Objection to Planning Application AW/197/20/PL

Planning Application AW/197/20/PL The former Ship Inn Variation of Conditions applied to previous Planning decision AW/211/14/PL

Articulated Deliveries Vehicle
with Refuse Vehciles Passing
scale 1:500 @ A1

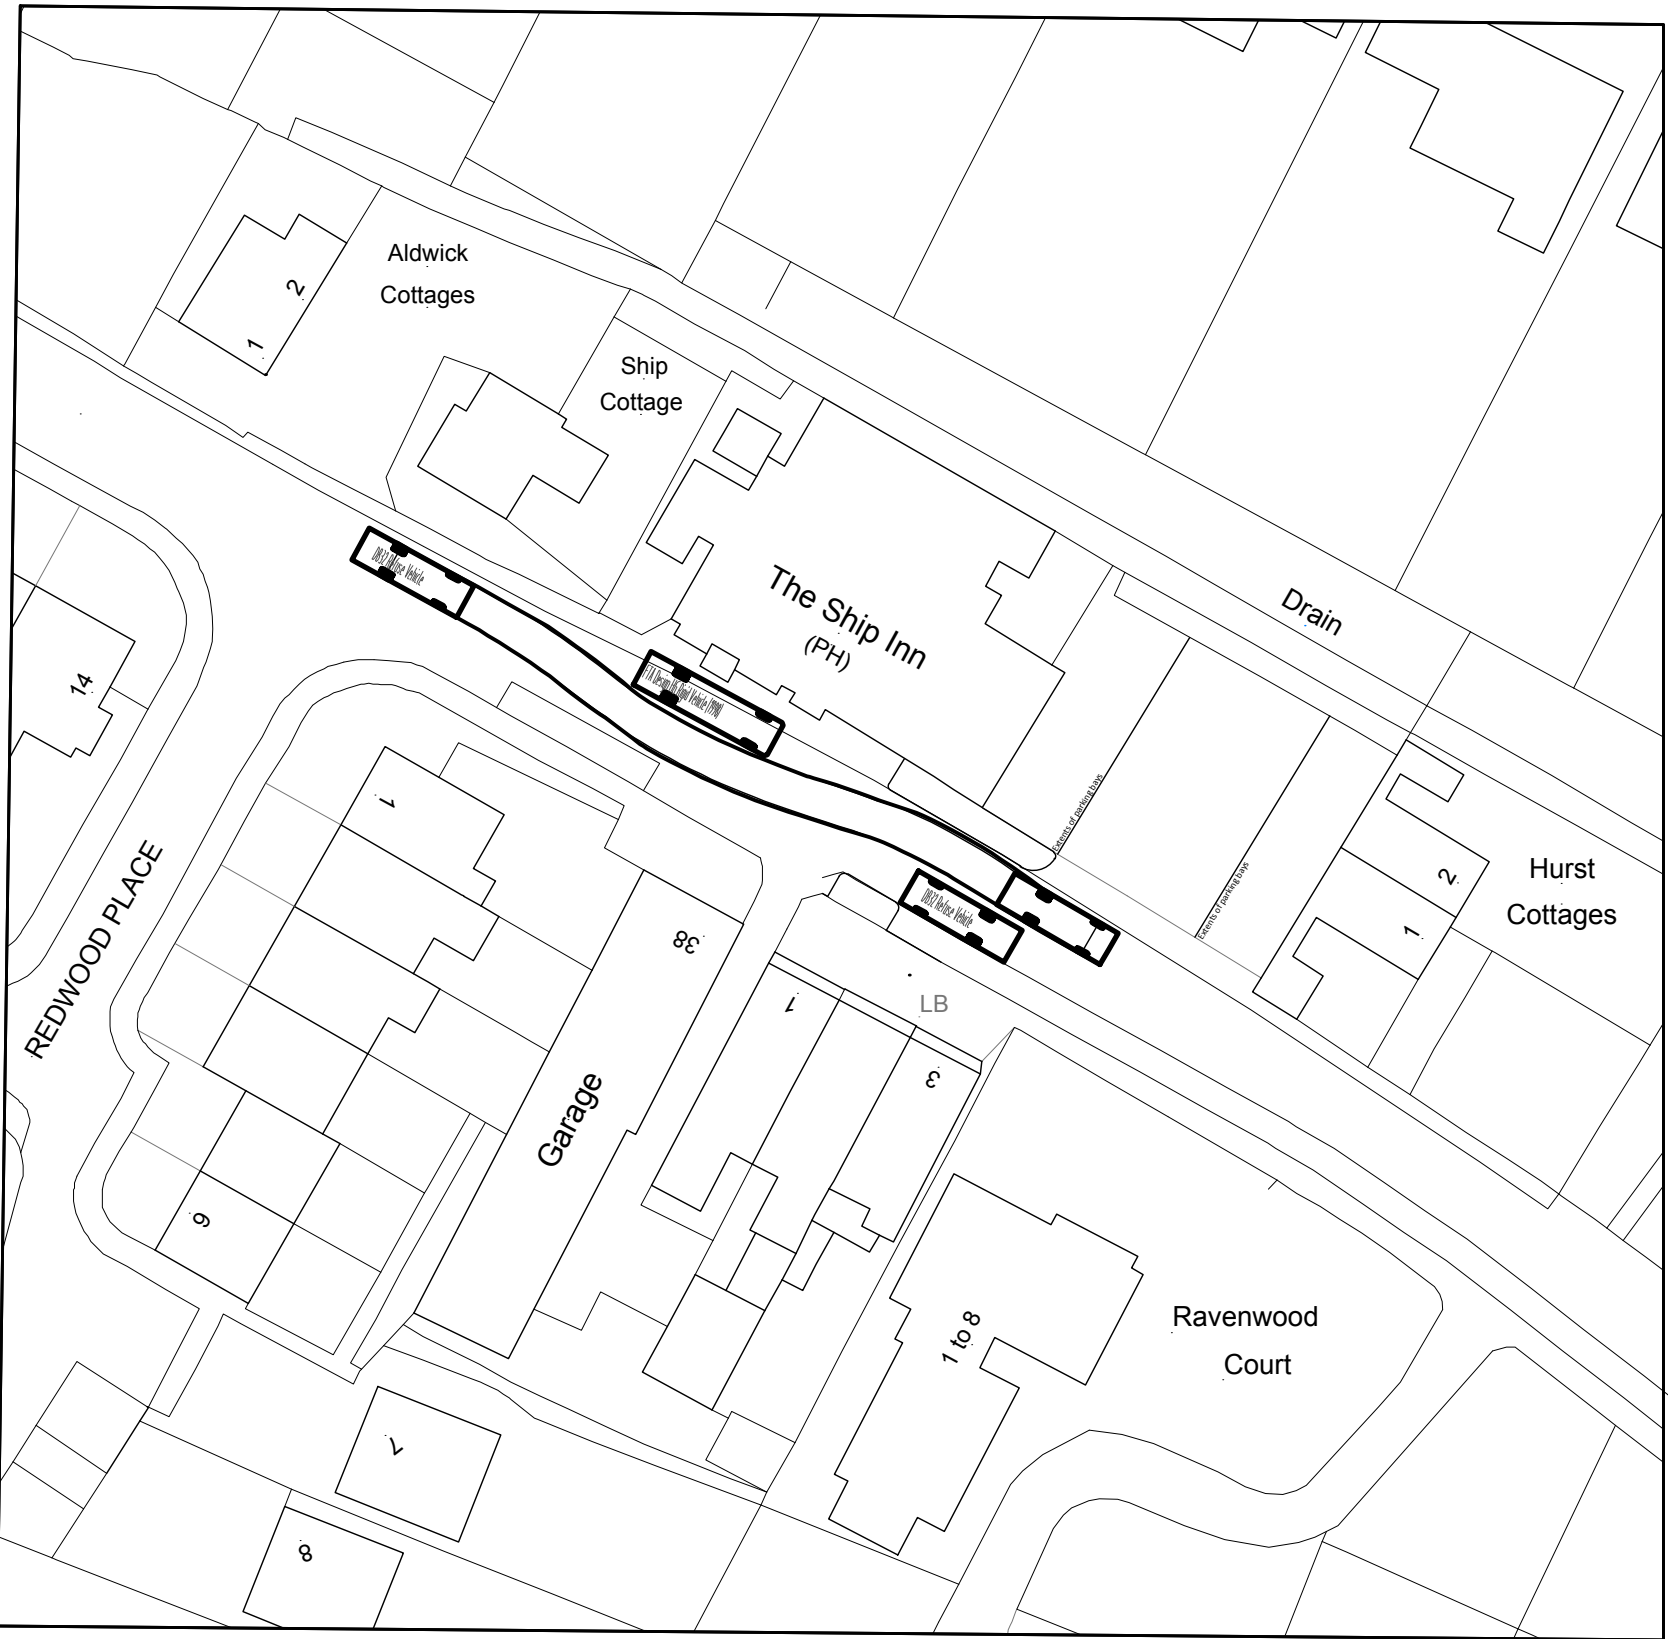
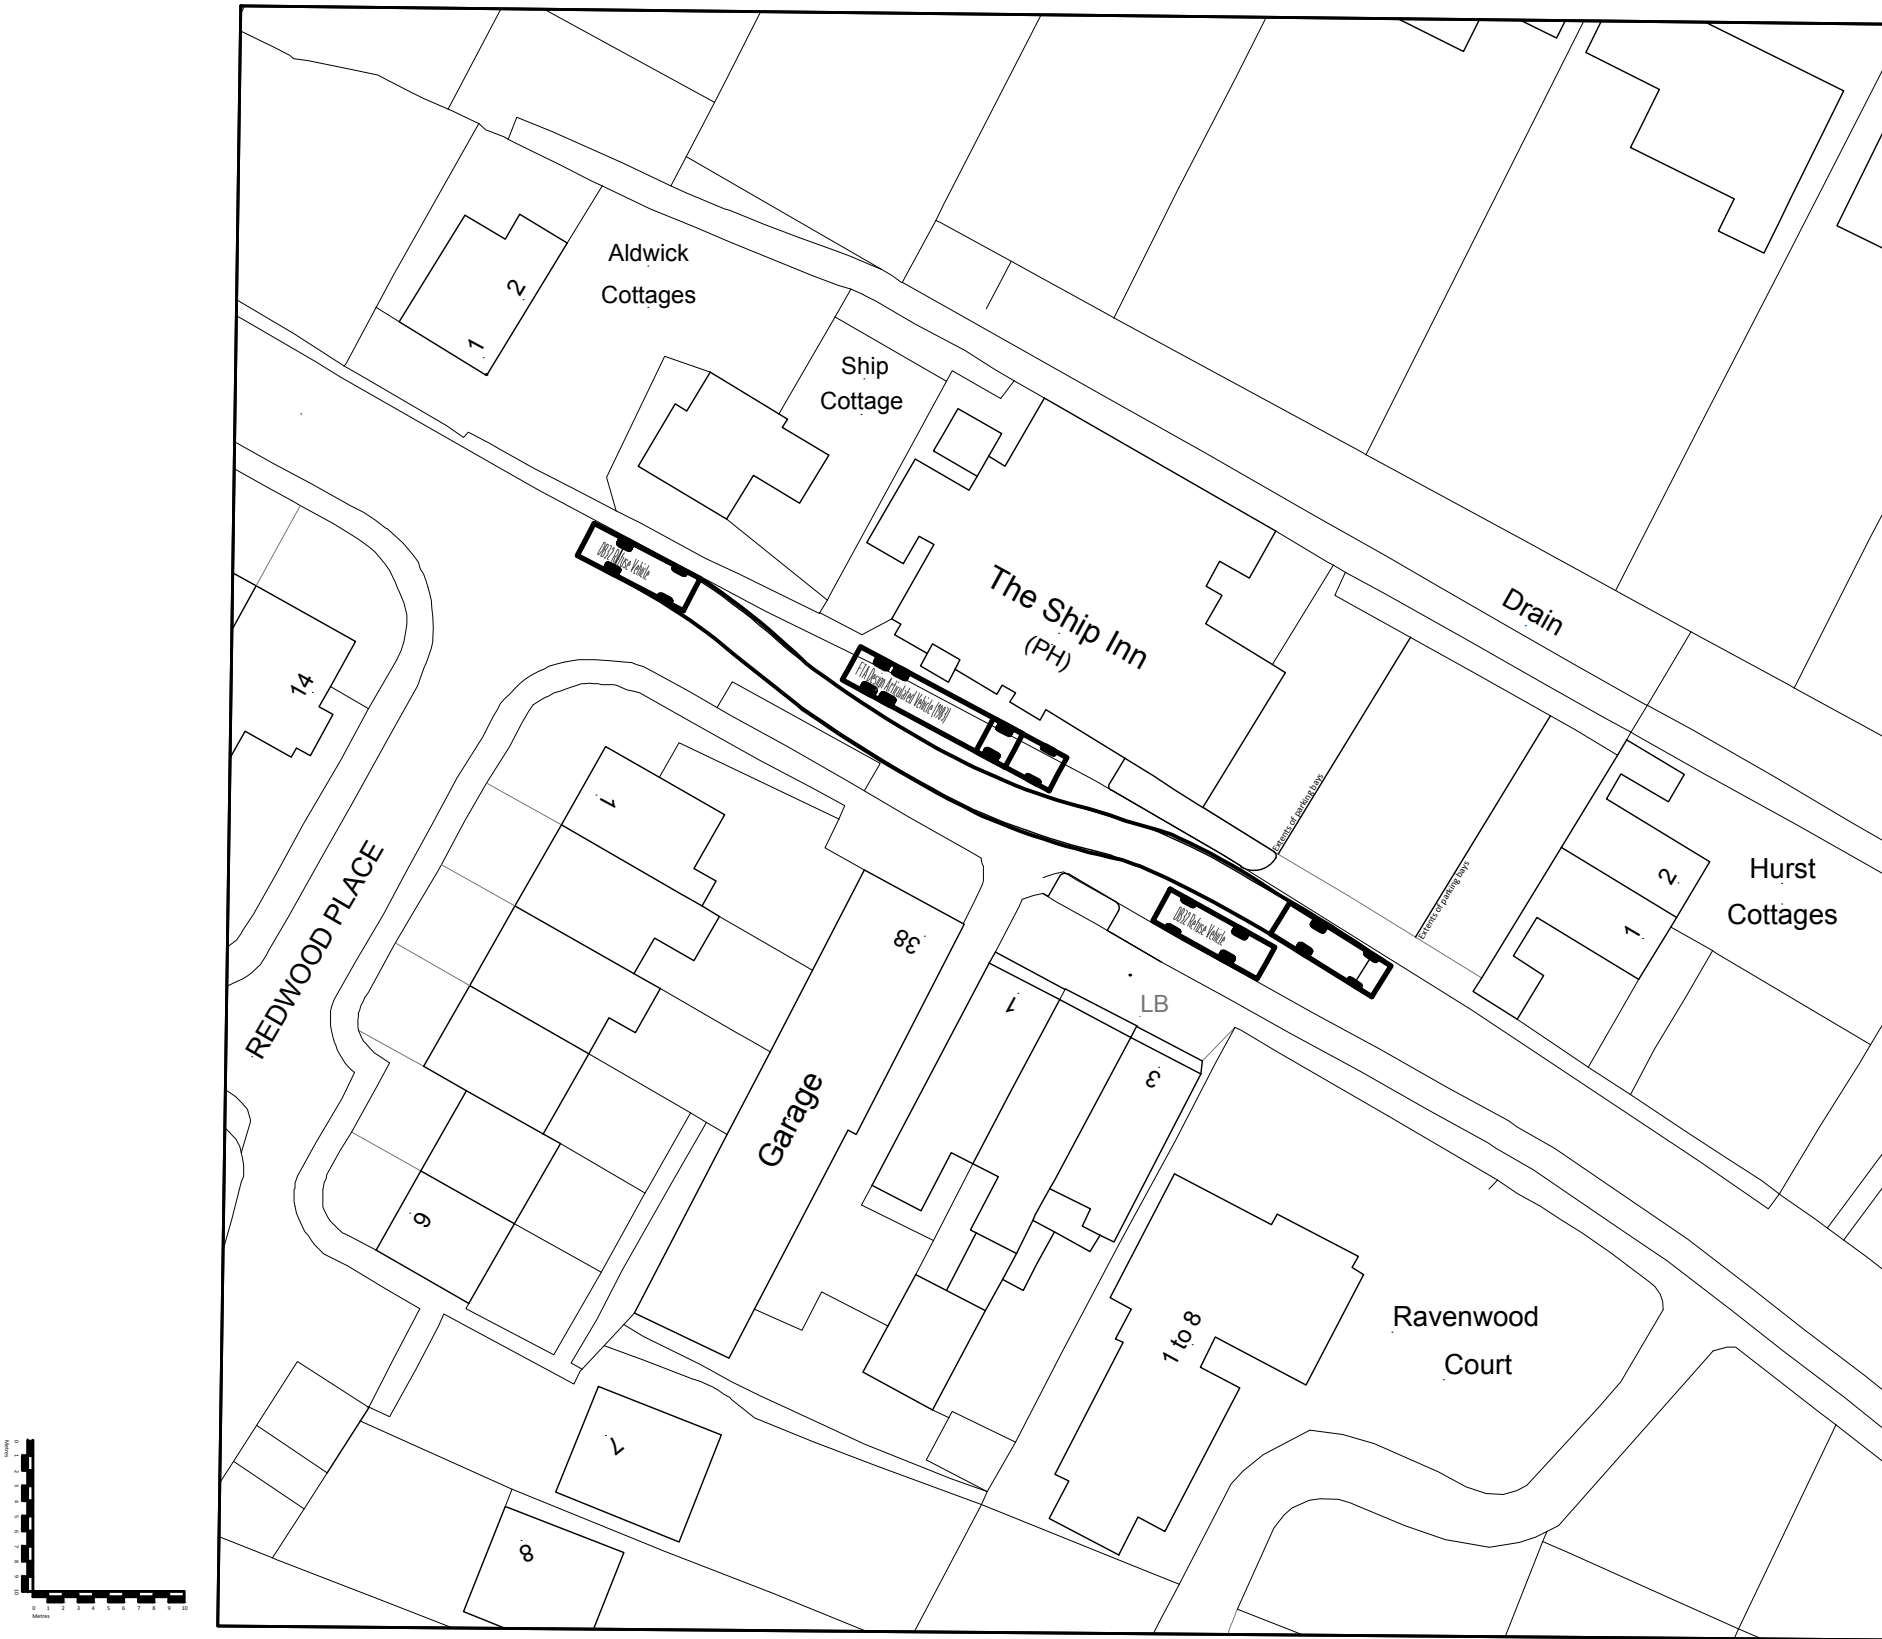
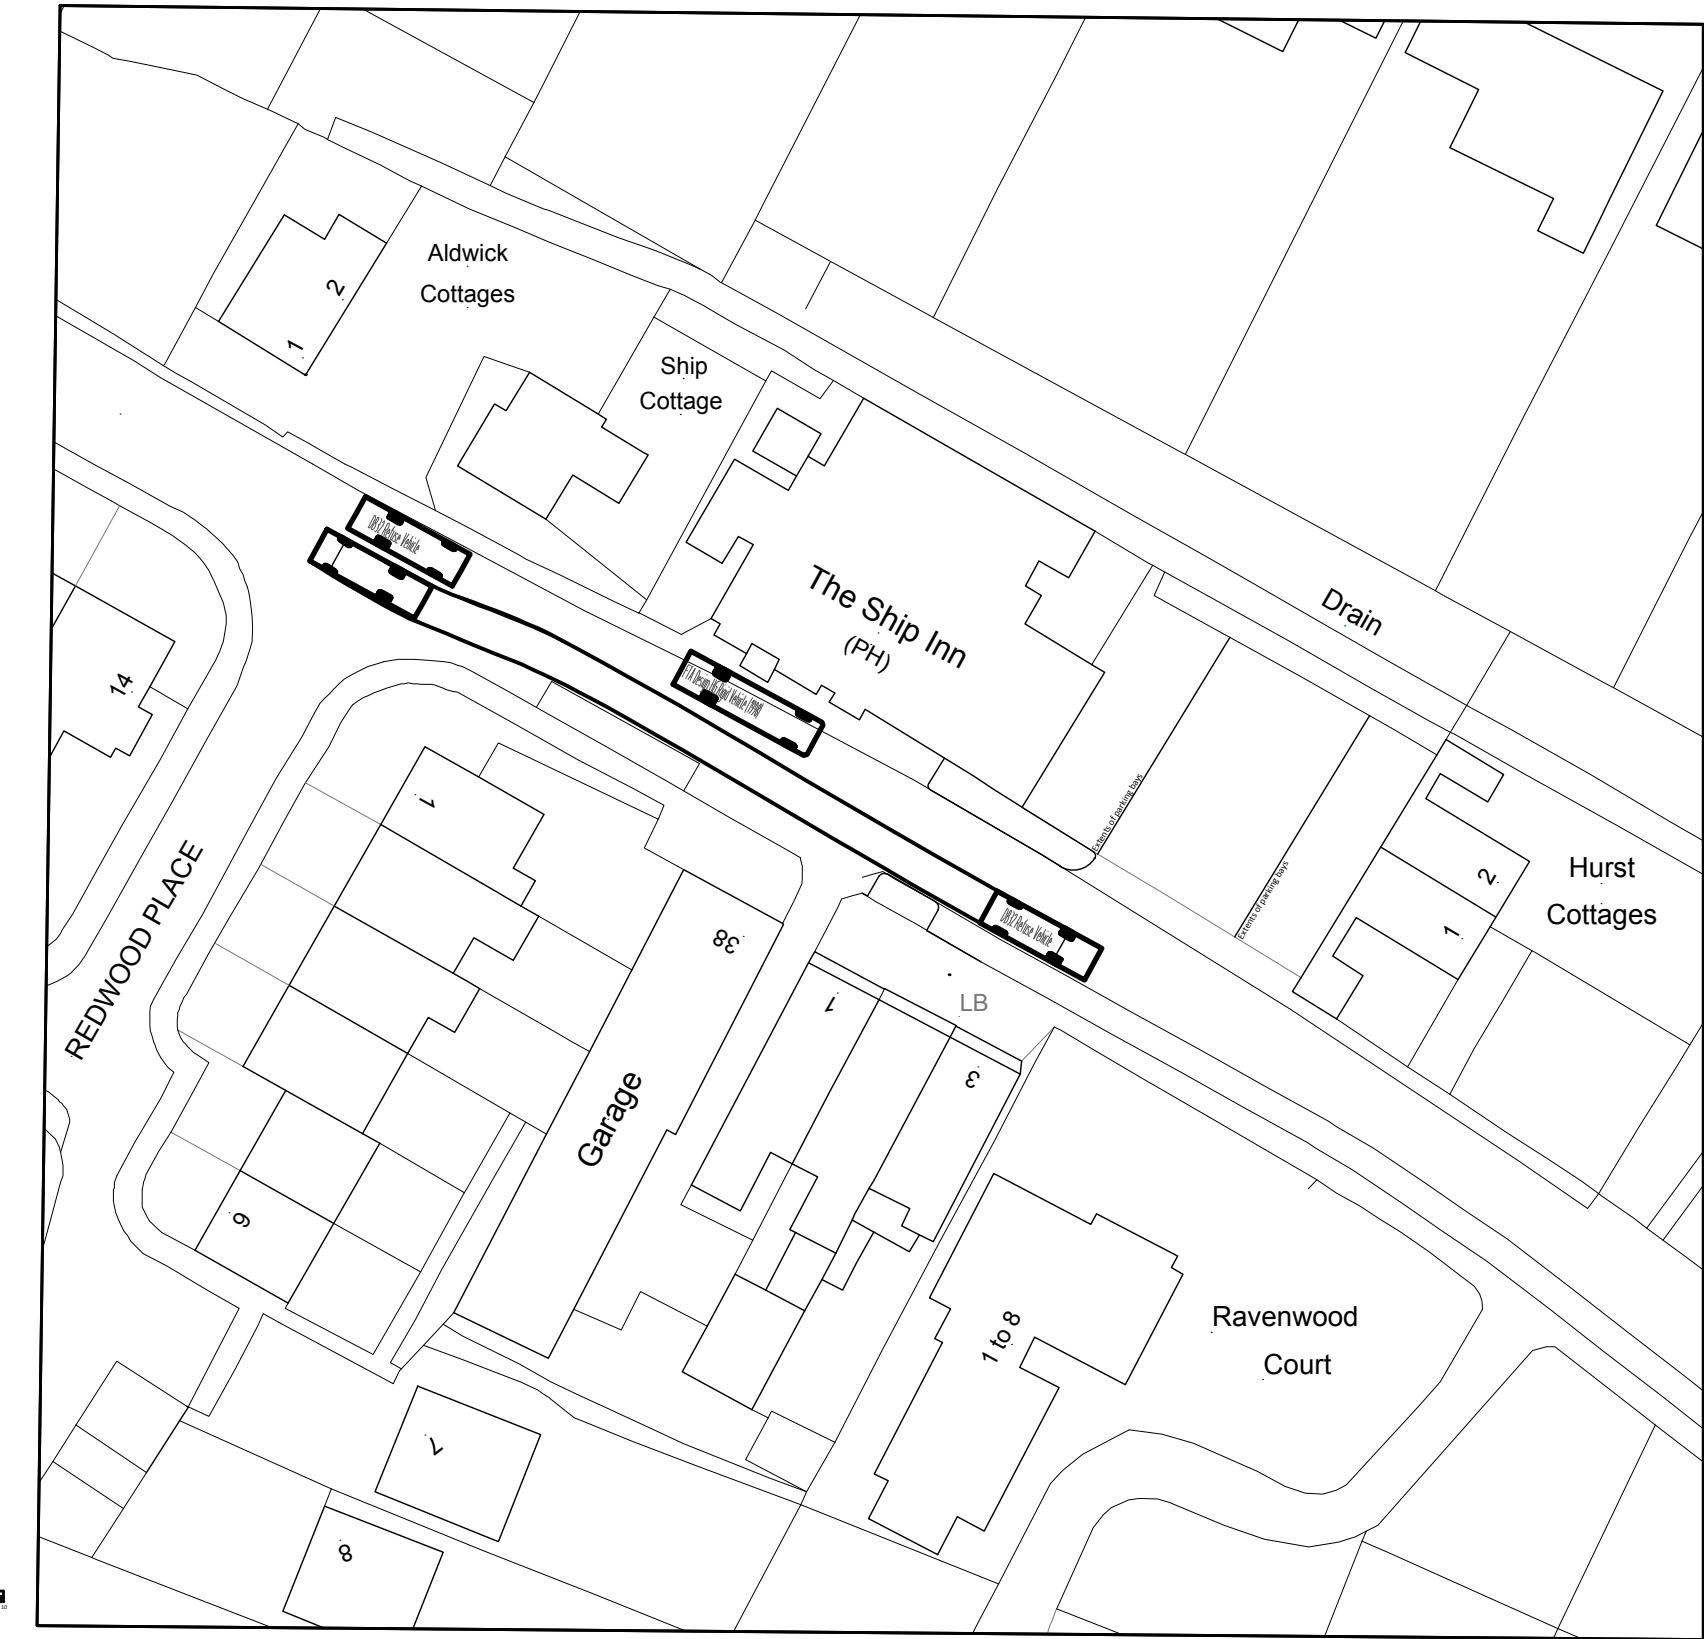
With traffic passing as close as given in the drawing B200038 B203 and B204 submitted, the unloading area will not be clear of other traffic.
